Submission by Sandell Consulting Regarding Barangaroo Ferry Terminal/Hub (SSI 6727)

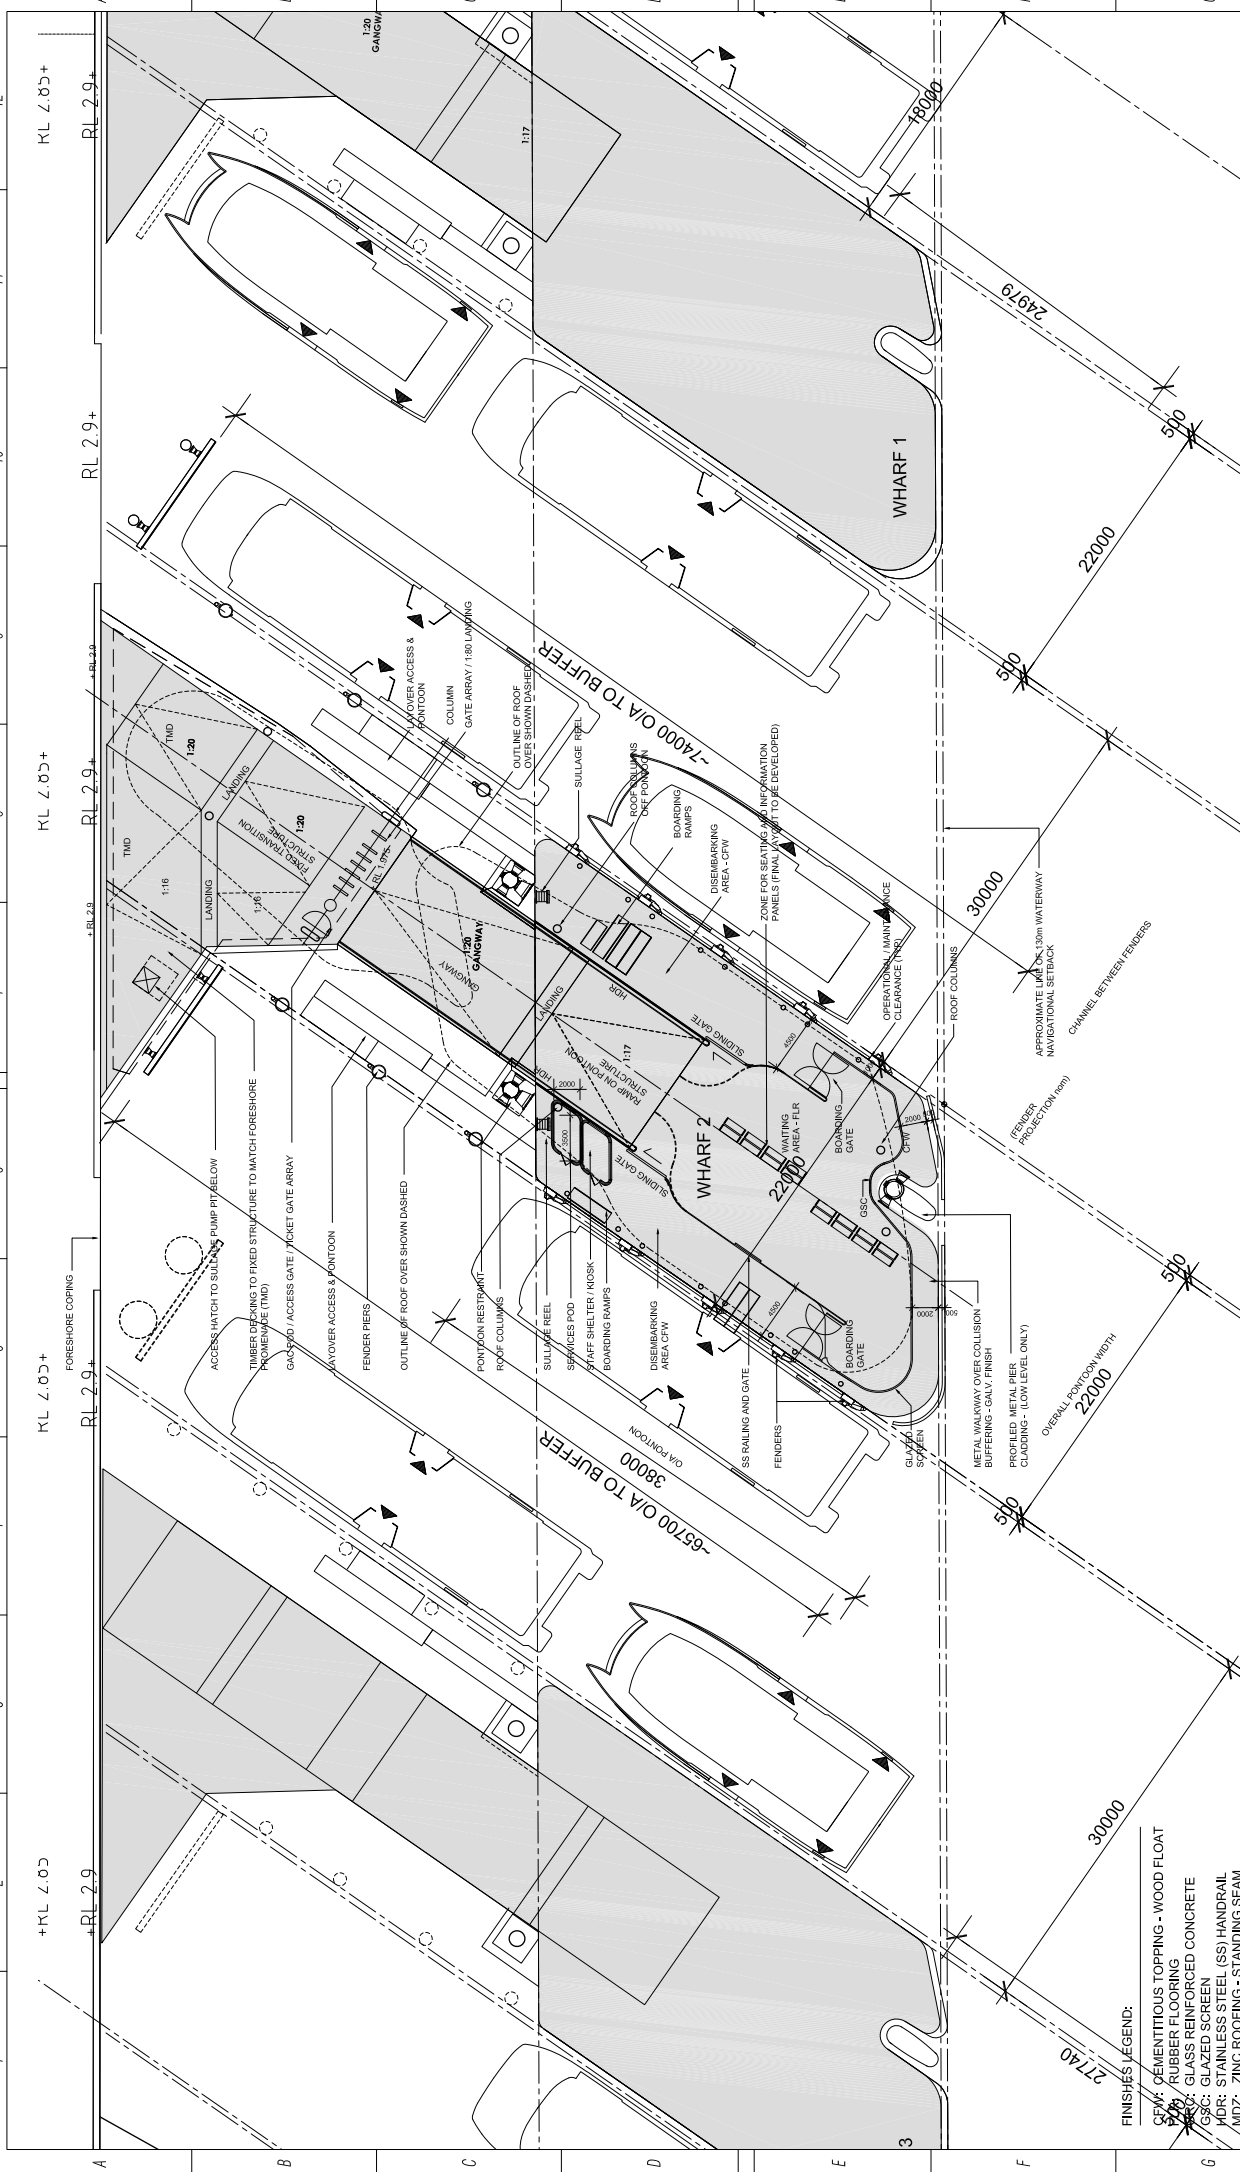
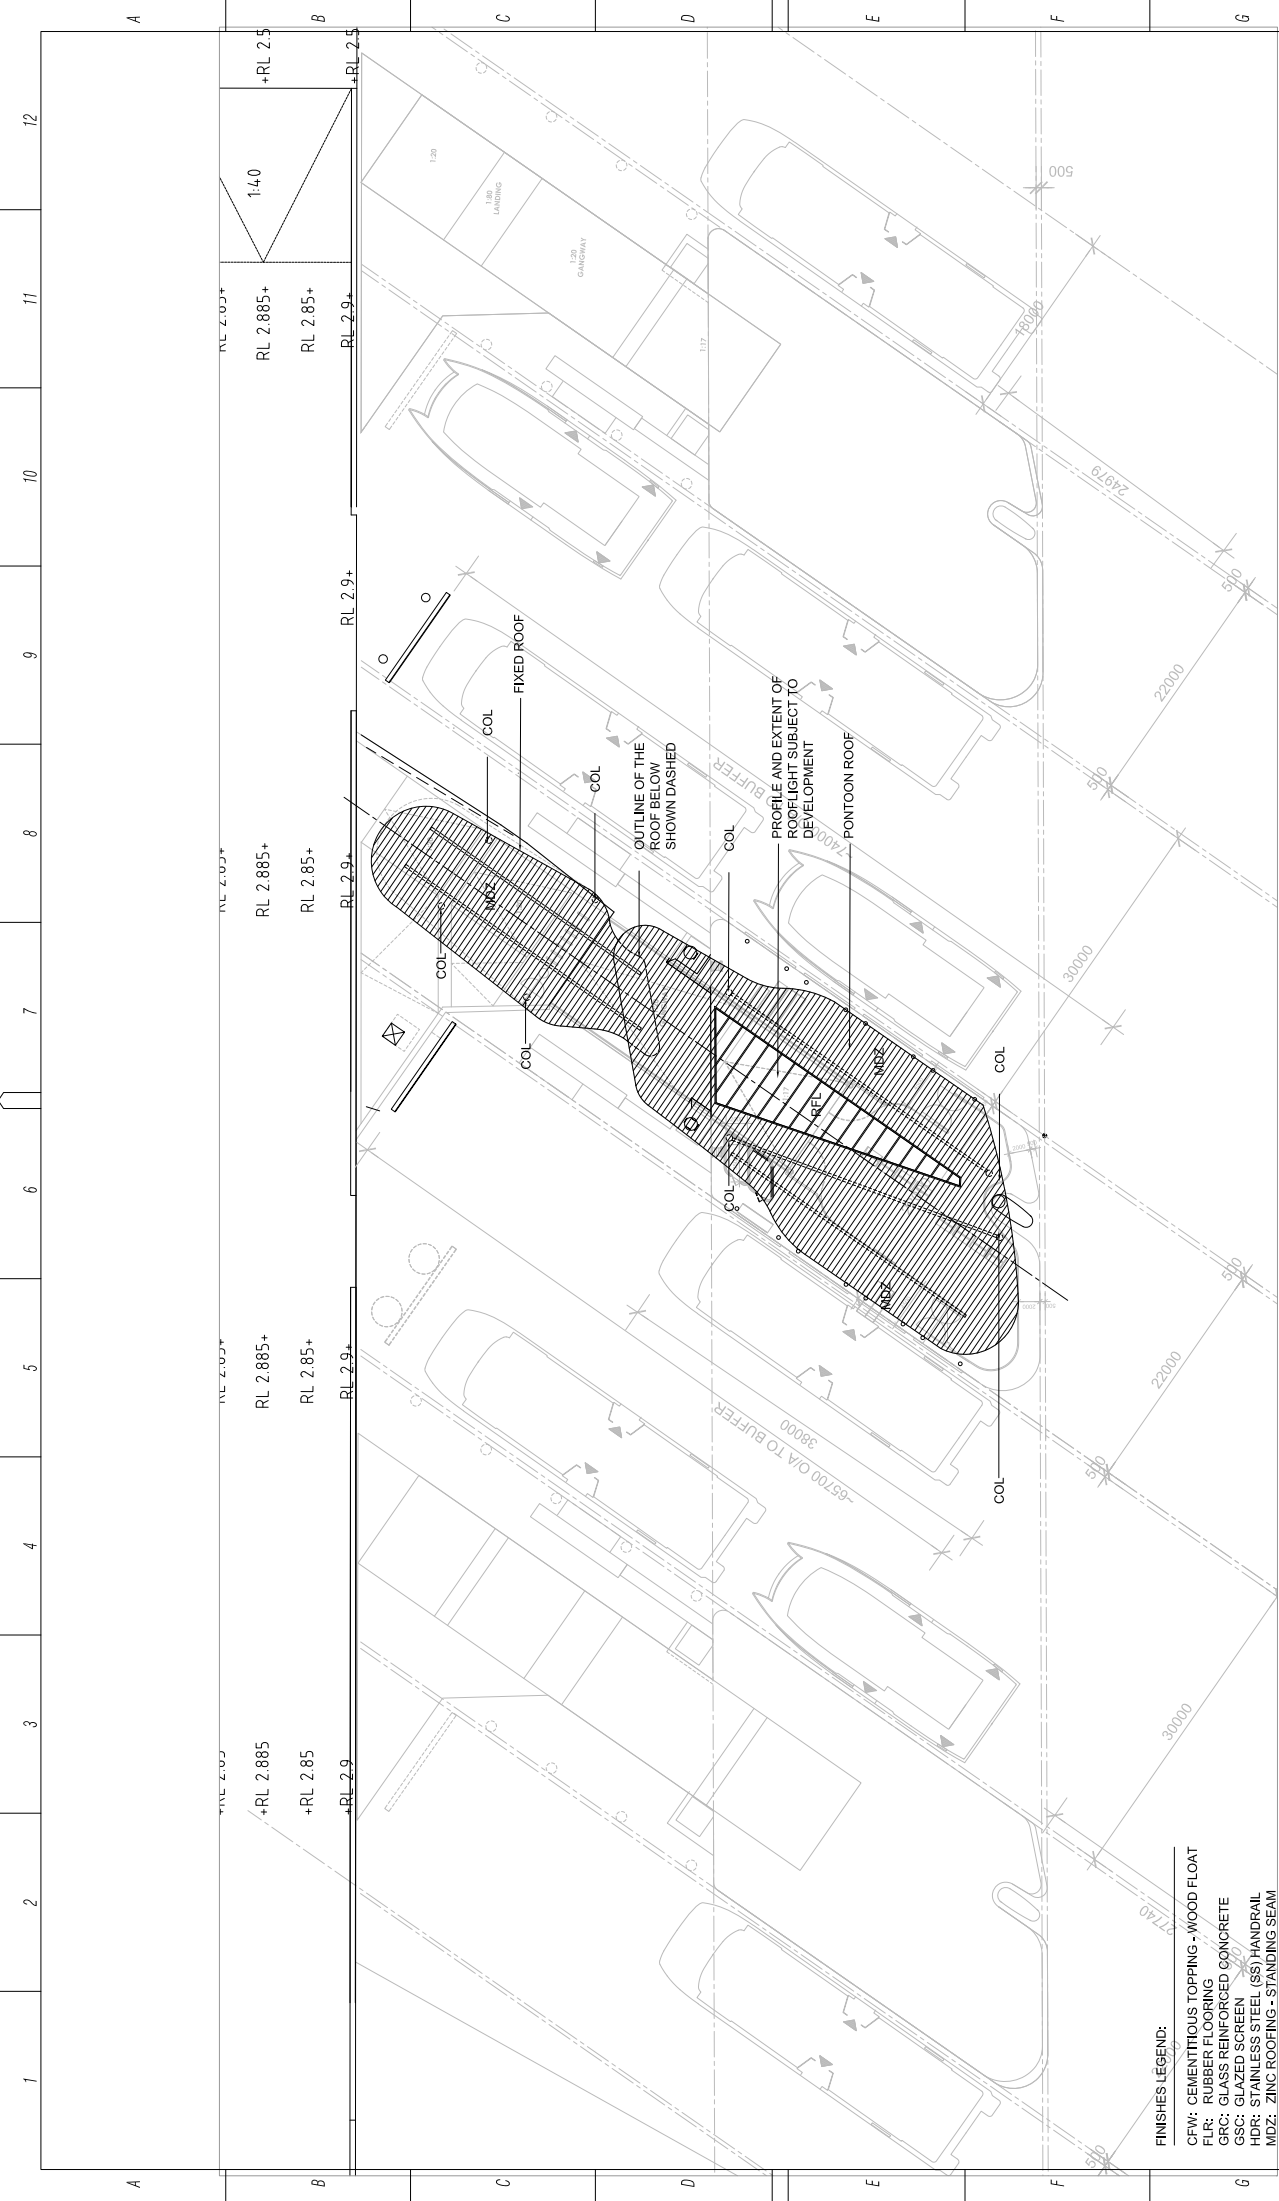
2. The pontoons need to provide a larger waiting area for passengers to avoid dangerous crowding, especially during events.
3. There appears to be an assumption that existing manually operated gangways will be used at the Barangaroo terminal. As there is a parallel project by Transport for NSW to design a new ferry fleet, this is an opportunity to incorporate more sophisticated gangway technology to speed up the loading and unloading of passengers.

The pontoons proposed for Barangaroo are wider than those at Circular Quay - 23 metres compared to about 18 metres at the Quay. Despite the pontoons being wider, the waiting areas do not appear to be large enough.

The combined waiting area for the two berths on each pontoon is about 200 square metres. This includes seating, which effectively reduces the available space. On busy days, it is quite conceivable that over 600 passengers will be waiting to board a First Fleet ferry on the north berthing face of a pontoon and a RiverCat on the south face. It is not safe, especially with multiple strollers and some passengers in wheelchairs, to cram three people per square metre into the waiting area. The US Transportation Research Board manual on Transit Capacity and Quality of Service advises that where densities are greater than 1.5 persons per square metre in a queuing area, "long term waiting is

Building the new terminal is also an opportunity to modernise gangway technology to speed up passenger loading and unloading. Whether this will be done at Barangaroo is not clear. The concept design drawings show mobile ramps which look similar to the current set up. It should not be impossible to design a better vessel/ pontoon interface which allows 400 passengers to quickly disembark and 400 others to quickly board.
